**OXFORDSHIRE COUNTY COUNCIL’S RESPONSE TO CONSULTATION
ON THE FOLLOWING DEVELOPMENT PROPOSAL**

Application no: 21/03268/OUT

Proposal: Outline planning permission (all matters reserved except for access) for the erection of buildings comprising logistics (Use Class B8) and ancillary Office (Use Class E(g)(i)) floorspace; construction of new site access from the B4100; creation of internal roads and access routes; hard and soft landscaping including noise attenuation measures; and other associated infrastructure

Response date: 28 April 2022

Section 6-6 (1:250 @A1)

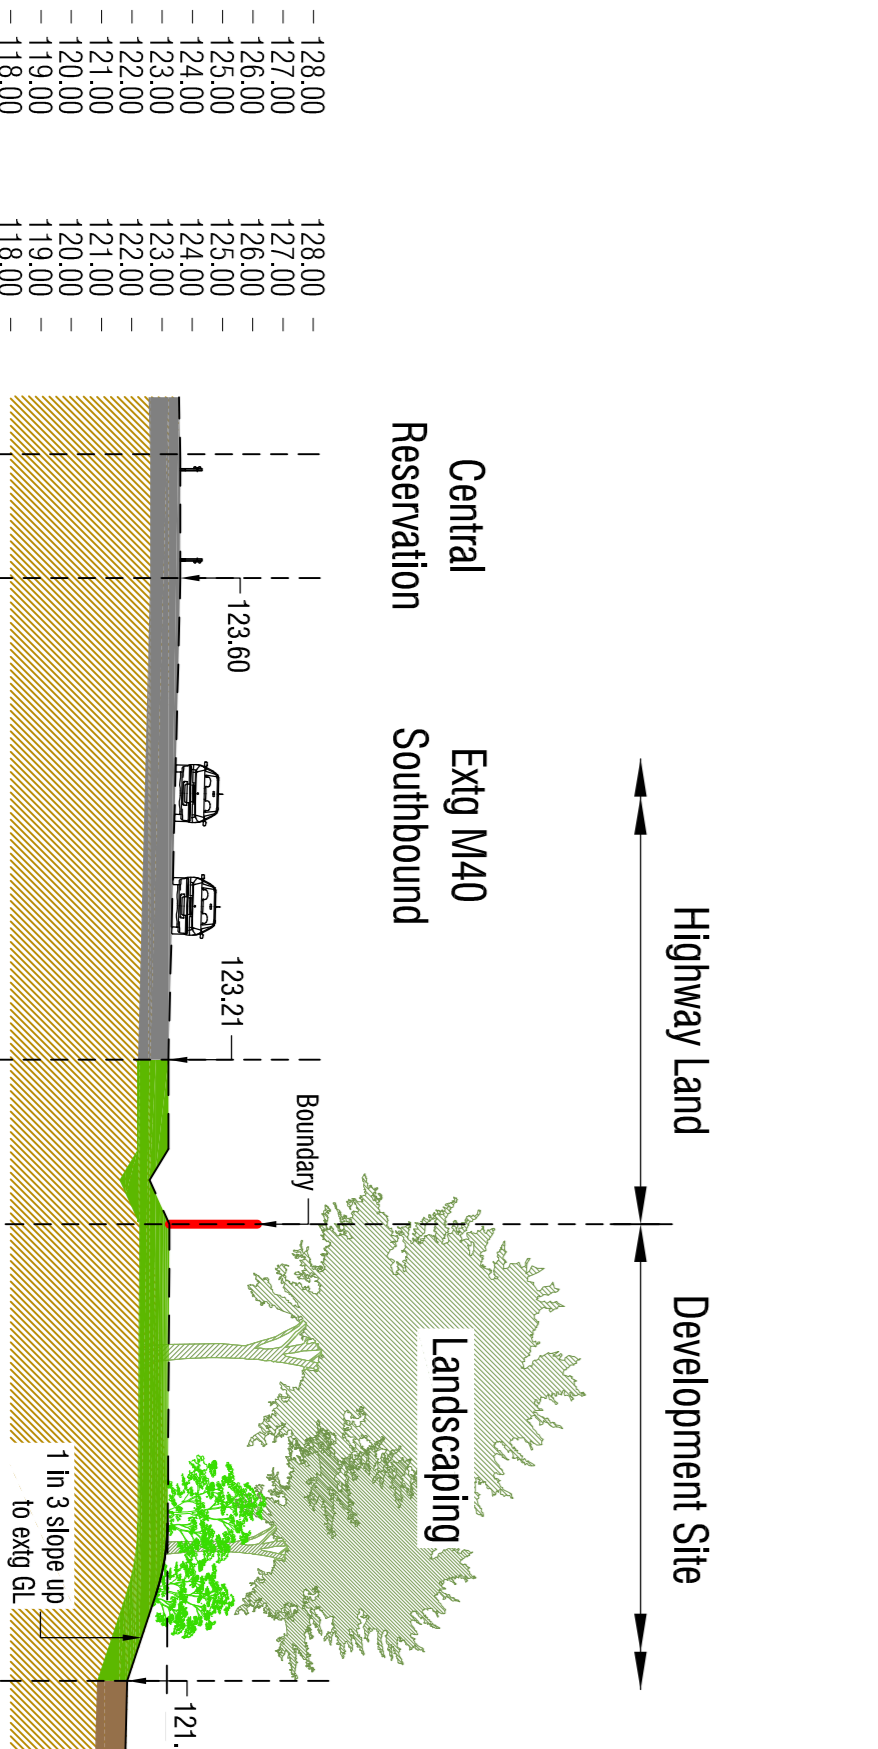
The further information also includes proposed cross sections which include alterations to the public highway. The Highway Authority reserves its position on these, pending agreement of the proposed highway arrangements, which are not approved (please see our previous consultation response).
